Modification of Minister's Approval

Section 75W of the *Environmental Planning & Assessment Act 1979*

Application No.:	MP 09_0165
Proponent:	Sydney Super Yacht Marina Pty Ltd
Approval Authority:	Minister for Planning and Infrastructure
Land:	Part Lot 32 DP 1151746 Sydney Super Yacht Marina 2 Maritime Court/Lot 2 James Craig Road Rozelle Bay
Project:	Land based redevelopment of Super Yacht Marina comprising: <ul style="list-style-type: none"> • Construction of two commercial maritime buildings with ancillary uses; • Construction of a multi-level car parking building; and • Off-street car parking and associated landscaping.
Modification Number:	MP09_0165 MOD 2
Modifications:	The modification to the Western Building only including: <ul style="list-style-type: none"> • design amendments to the building design and siting; • reduction in the building GFA by 255m² to 2,645m²; • amendments to the location of the ground floor uses; • the addition of two external fire stairs; and • deletion of 13 car parking spaces.

Site Plan

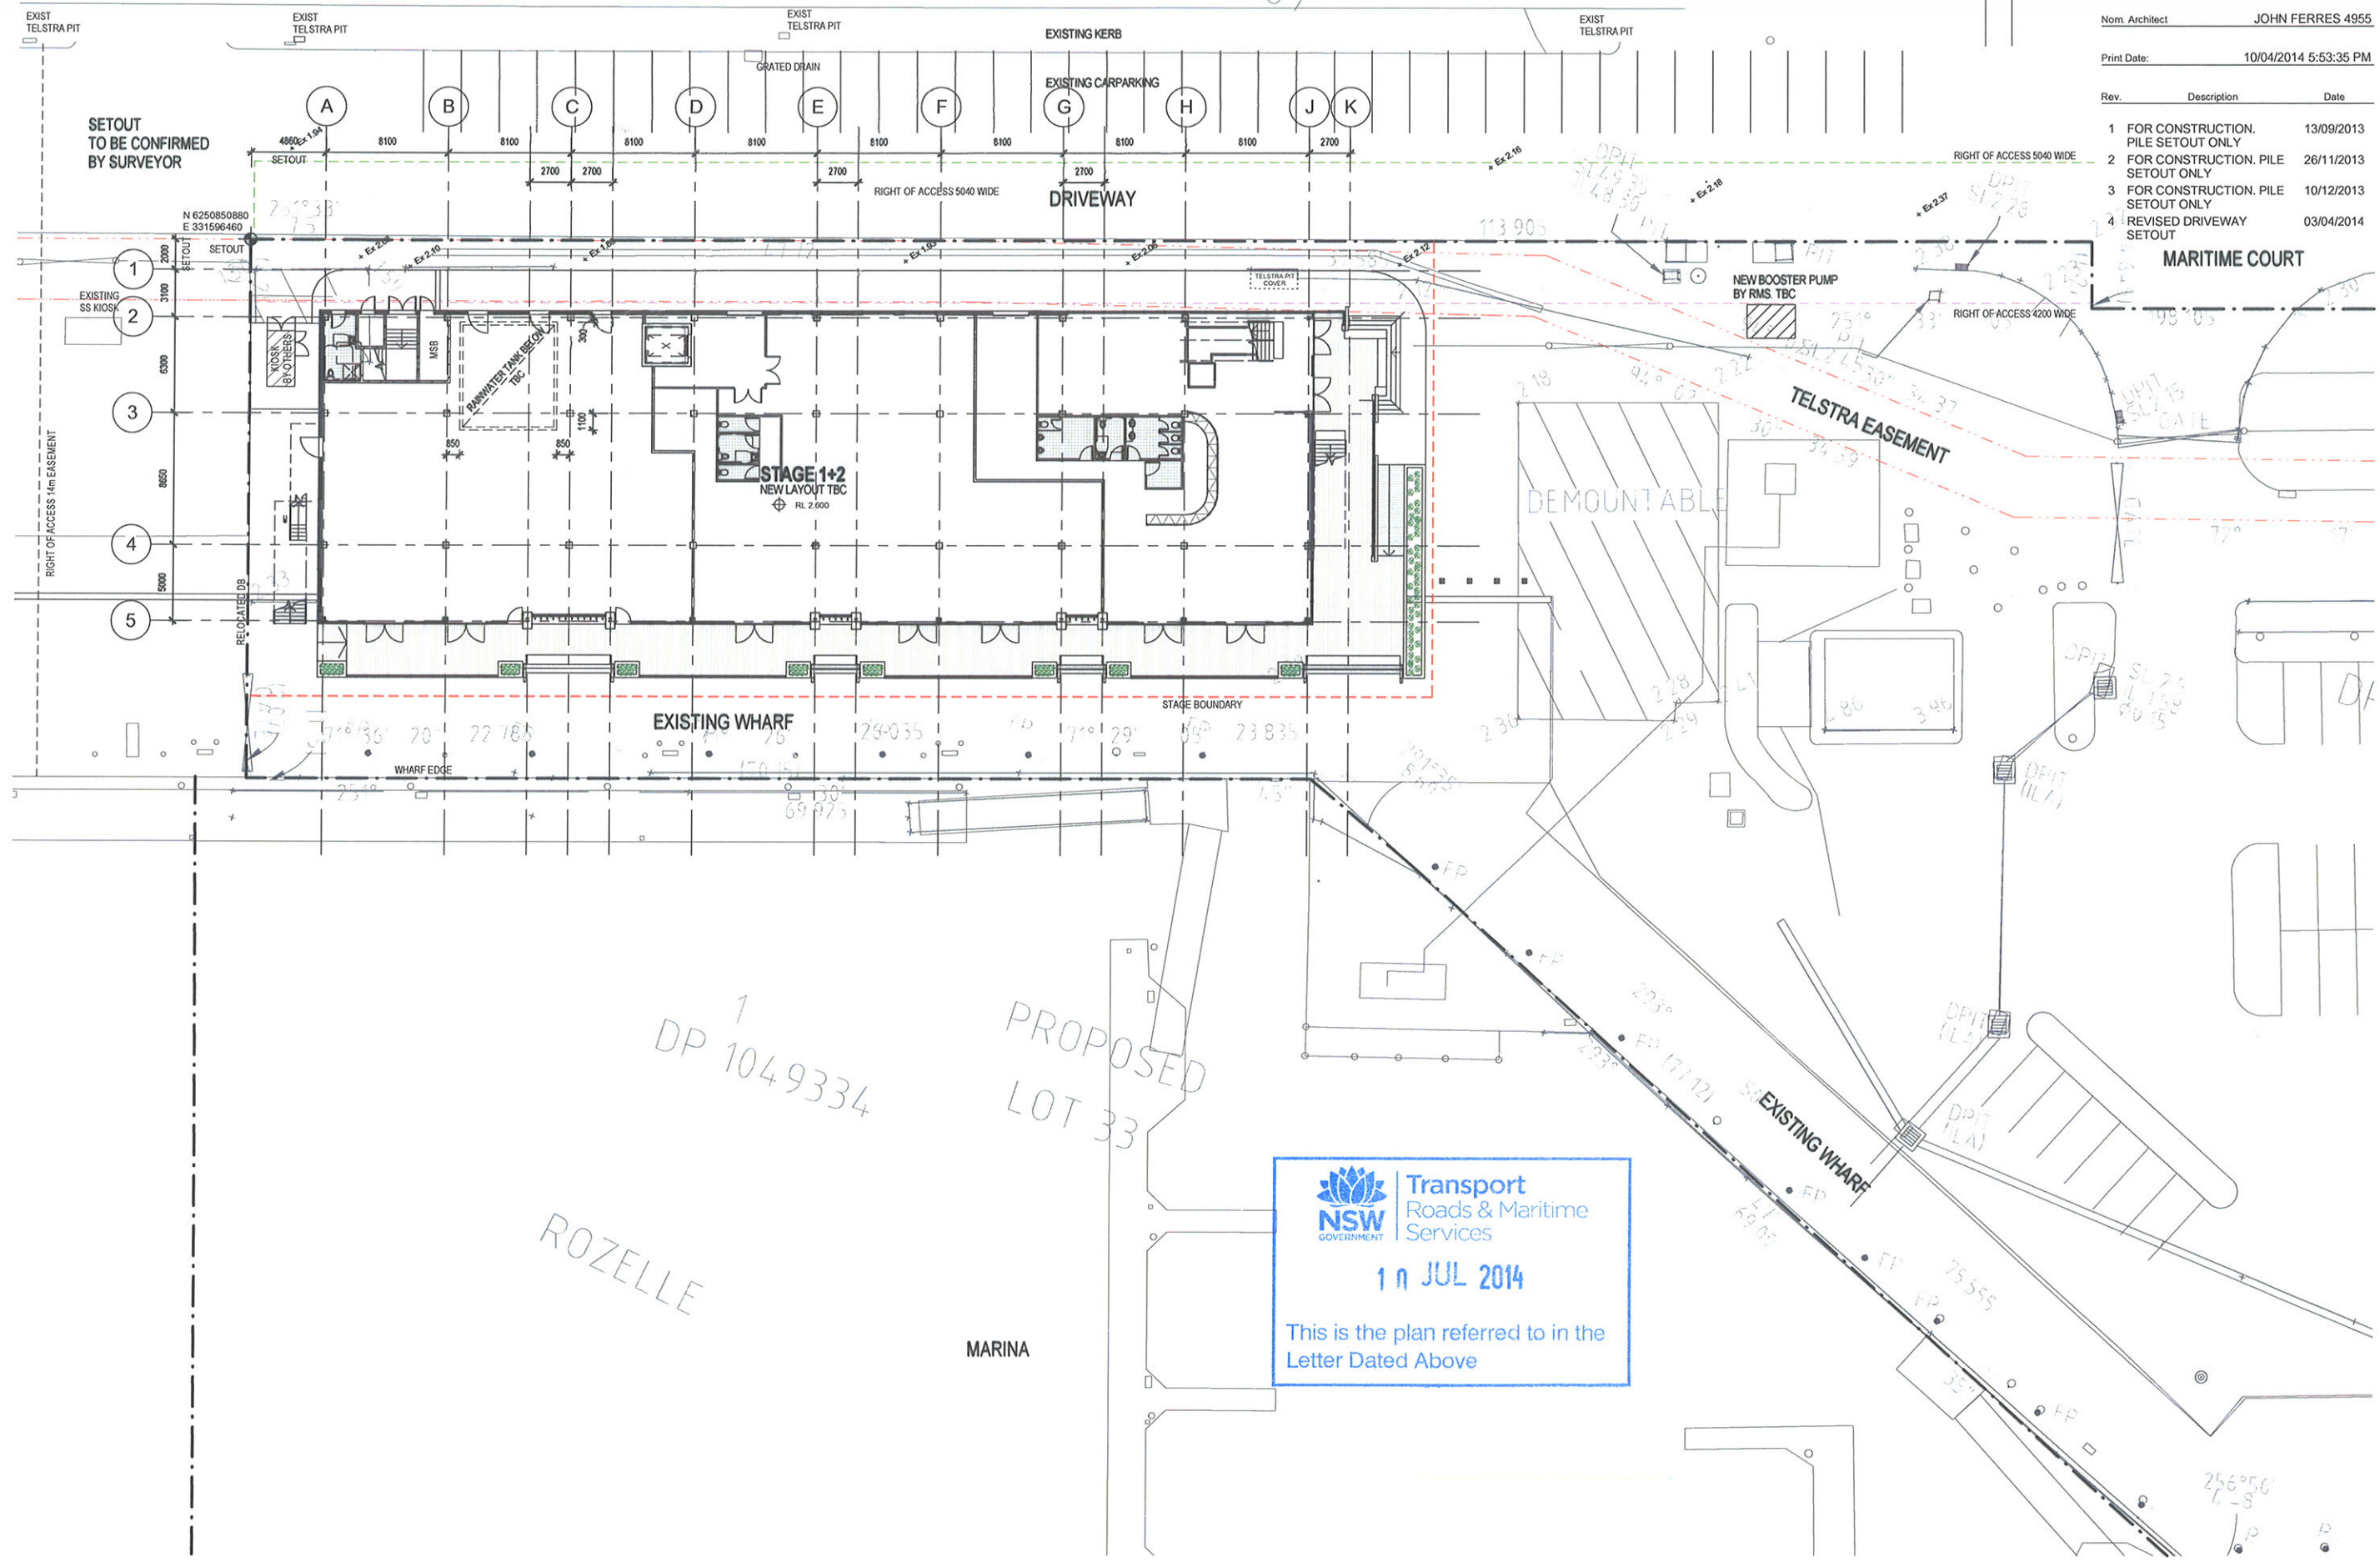
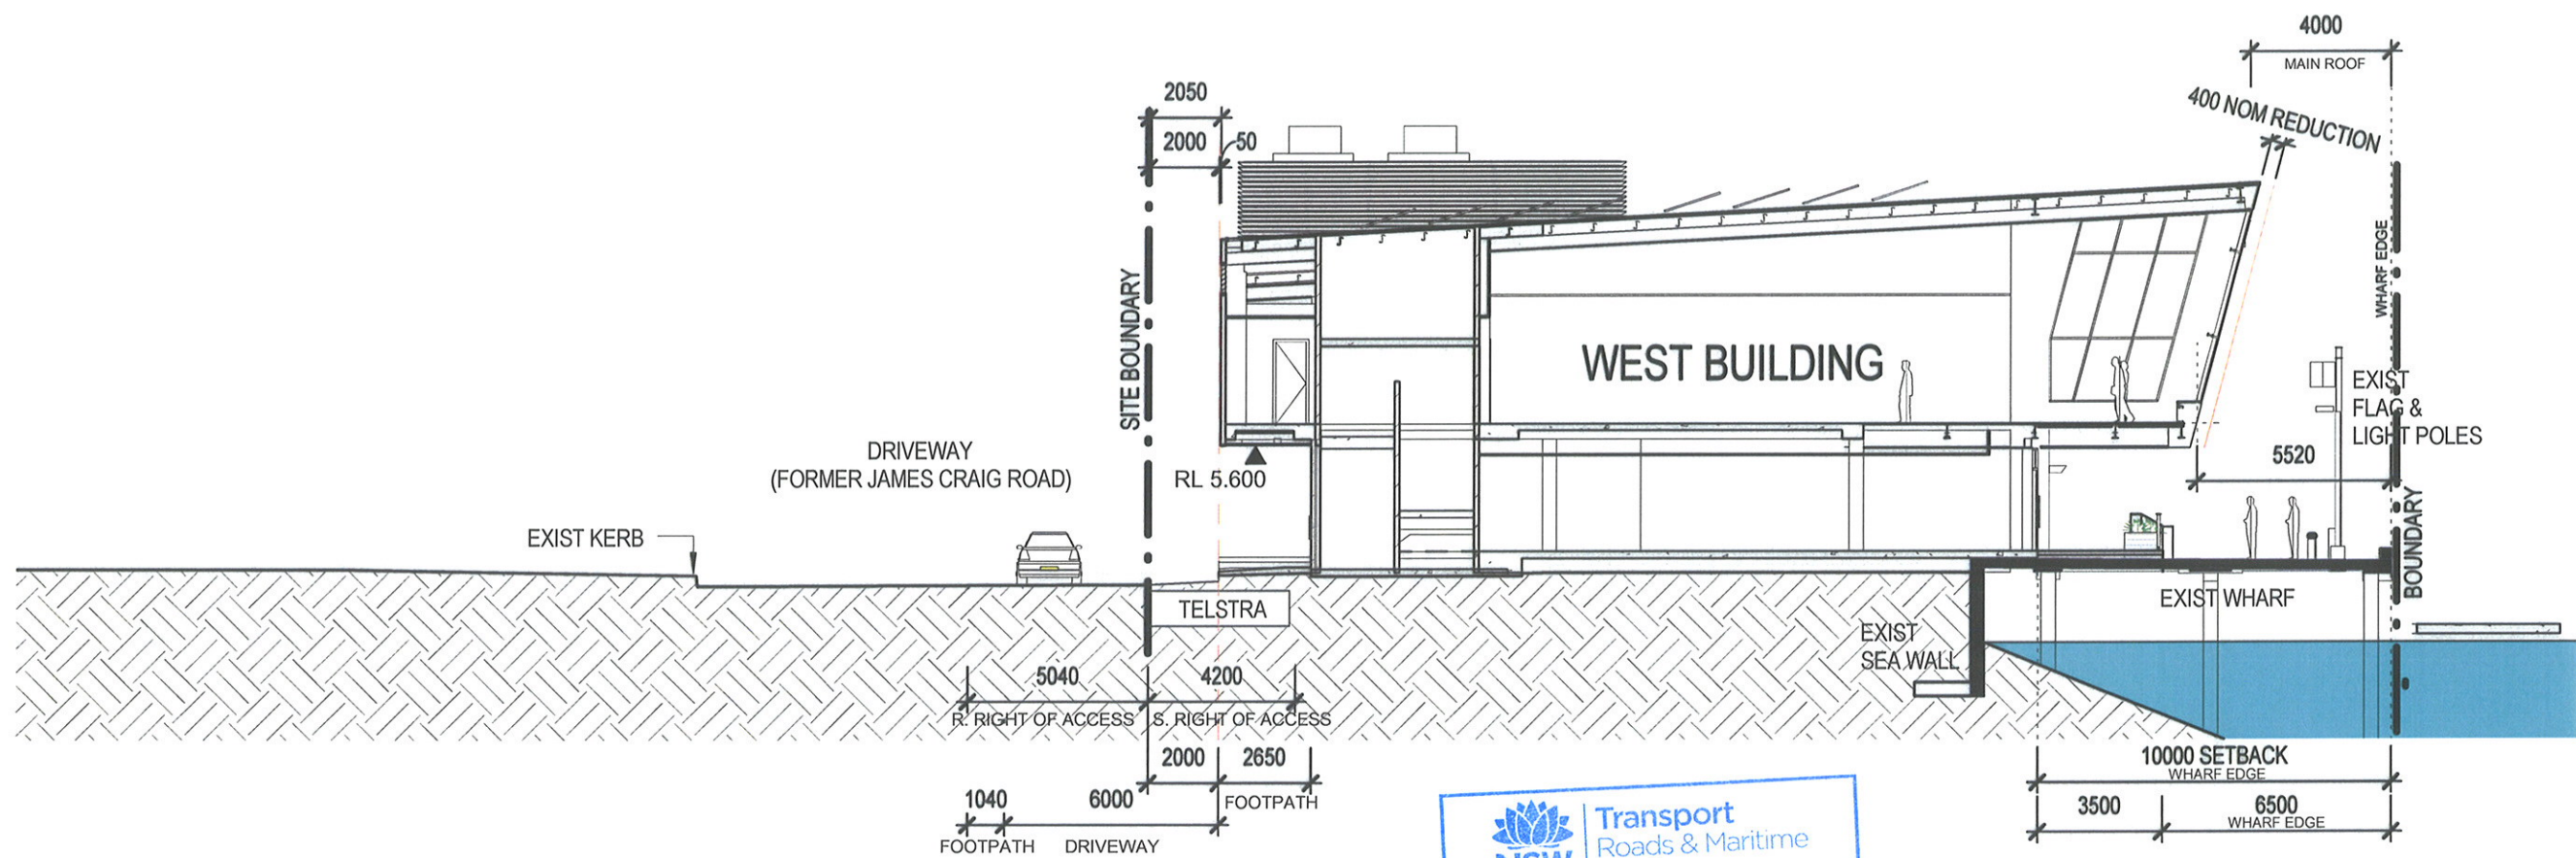
**Drawing 20090002-AD-002 is approved only in respect to the siting of Western Building.

CROSS SECTION
Drawing Number: 20090002-AD- SK932 -C
9/04/2014 4:41:46 PM

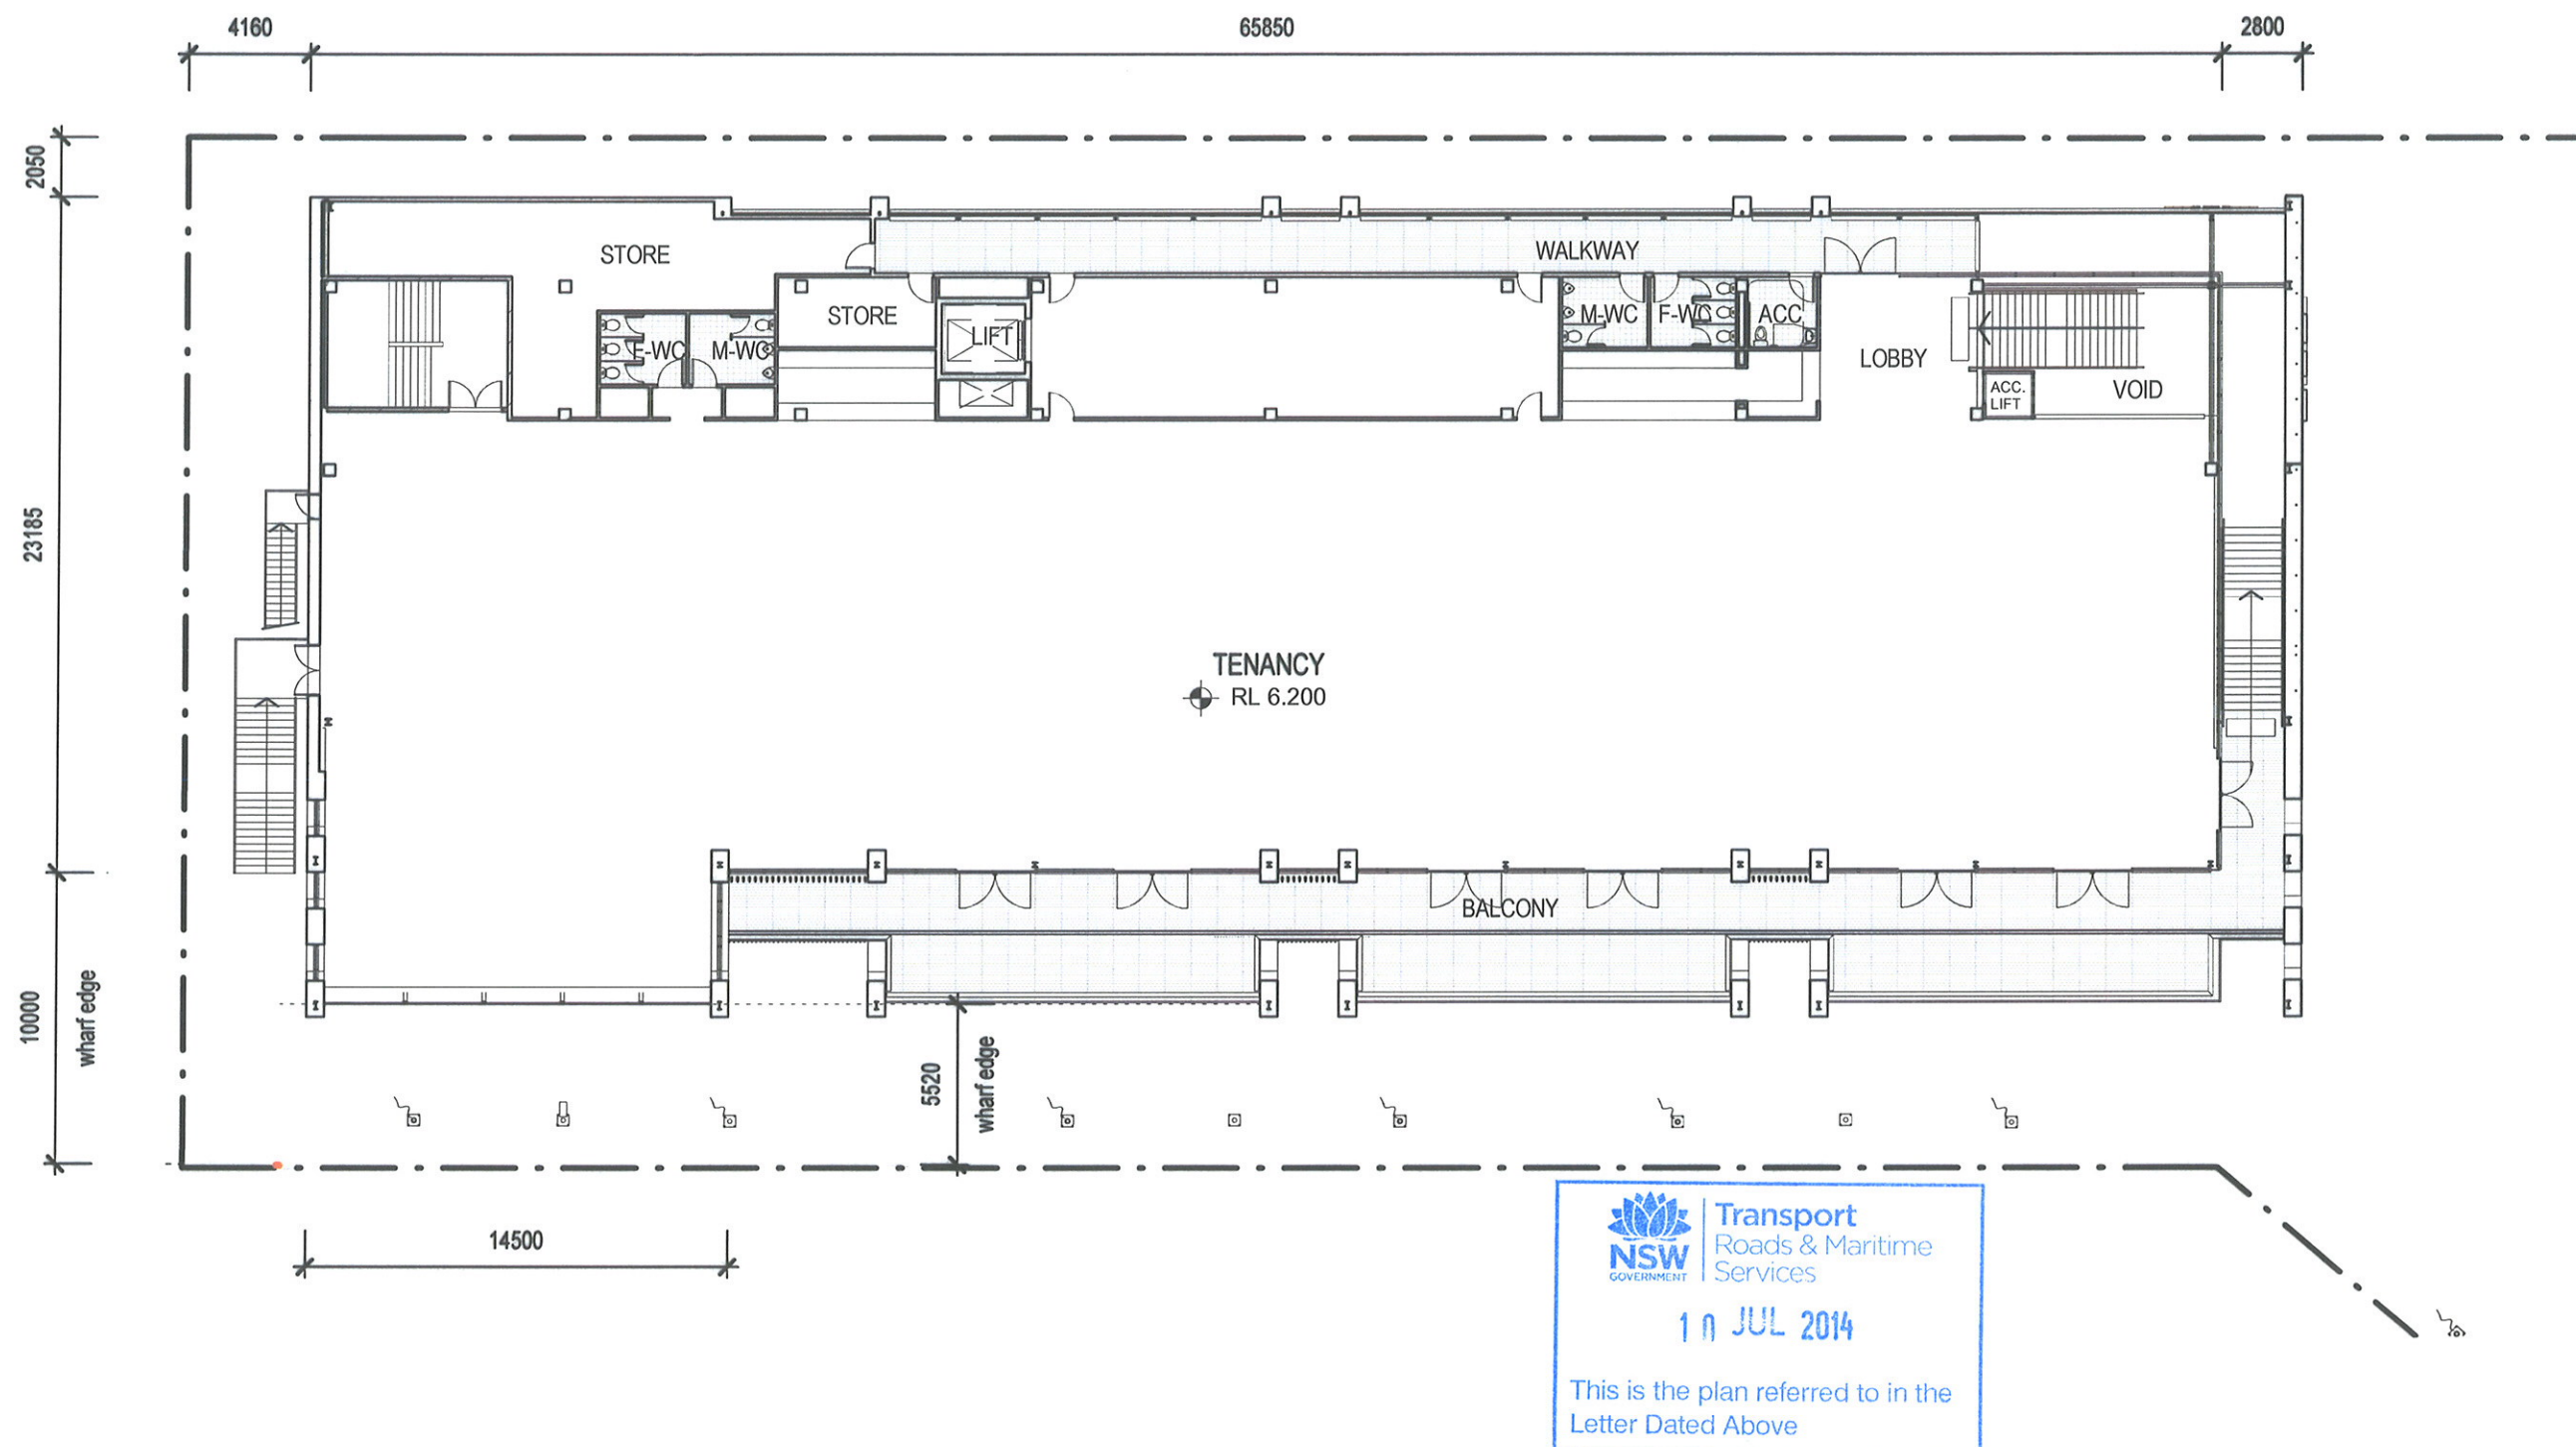
*Drawings DA08 and DA12 are approved only in respect to details shown for the south and north elevations of the Western Building. The RL's shown on DA08 are not approved and are superseded by those heights nominated on plan SK932-D.

- ***that the heights for the western building do not exceed the following:***
 - ***top of roof plant and plant screens: RL14.600 and RL13.580, respectively; and***
 - ***main roof parapet: RL12.900.***
- ***that the main roof of the western building (parapet, Level 1) is setback a minimum of 4.00 metres from the wharf edge.***
